C1.2

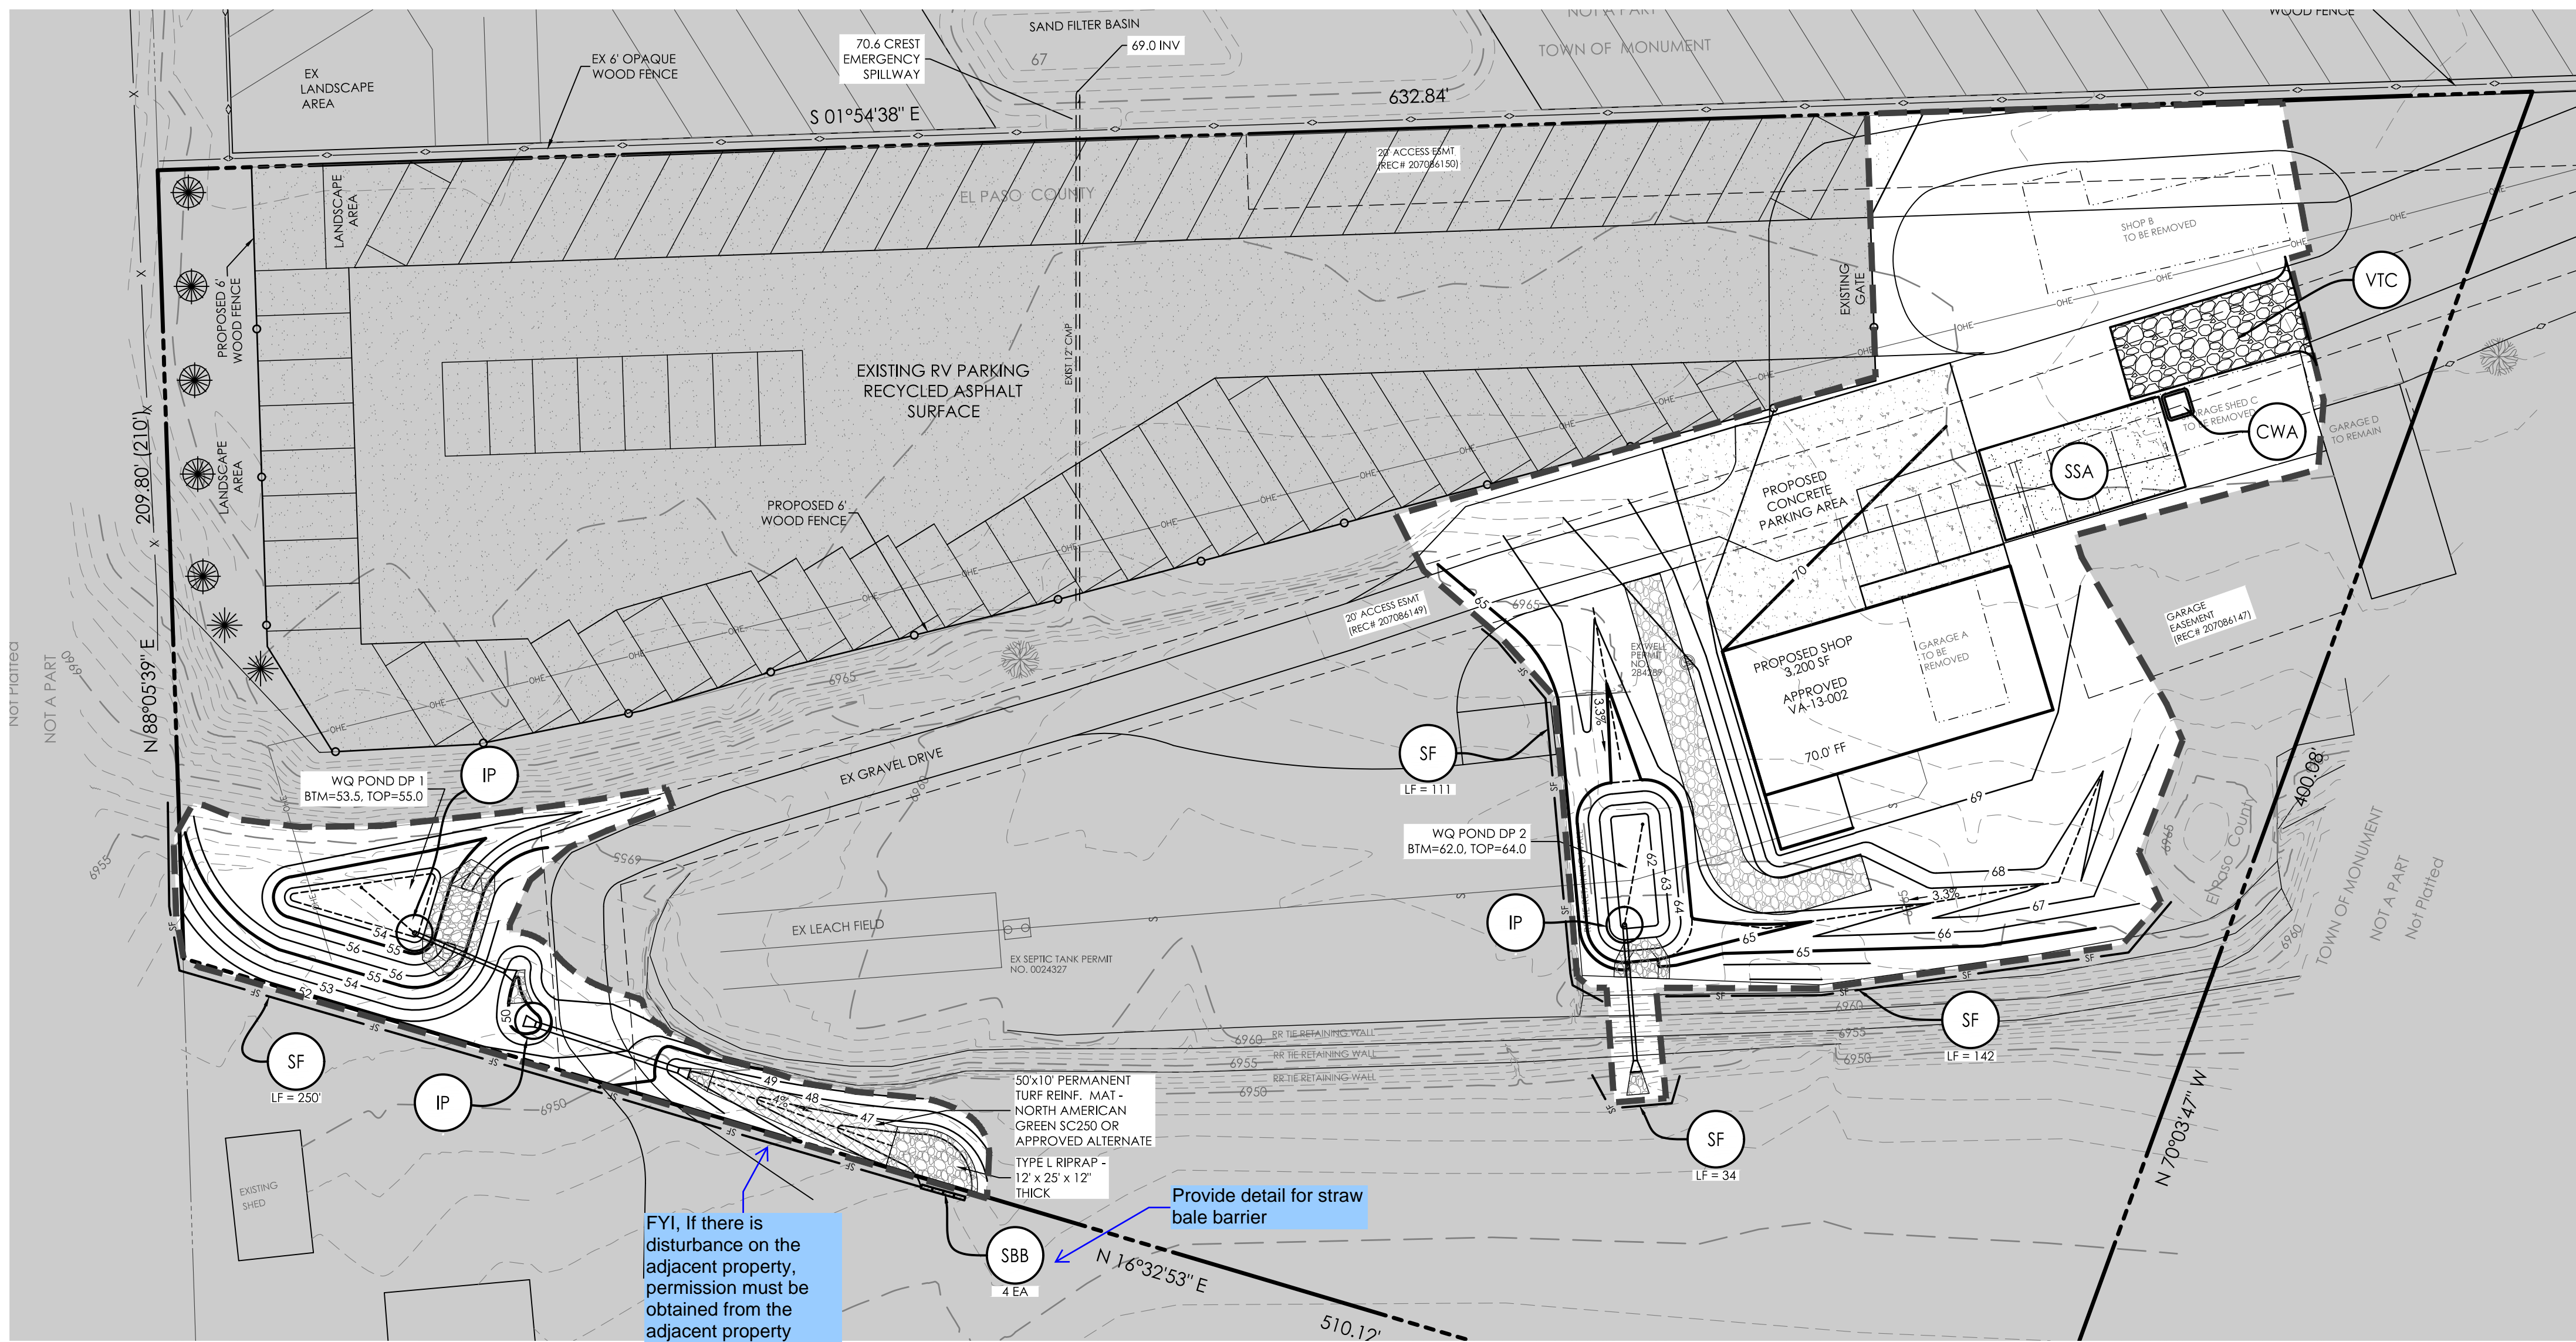
Provide letter of approval to work in the adjacent property.

Based on the existing contours, discharge from the outfall and spillway location appears to be directed to the existing structure downstream on the adjacent property; therefore this does not appear to be a suitable outfall.

Additionally, provide a copy of a written approval from the adjacent property owner for the proposed off-site improvement.

Per ECM 3.2.4, a suitable outfall refers to a stream which is a hydraulically adequate natural stream or channel segment. Therefore provide conveyance from the outfall to the existing creek.

Per ECM 3.2.4, a suitable outfall refers to a stream which is a hydraulically adequate historic natural stream or channel segment. Therefore provide conveyance from the outfall to the existing creek.
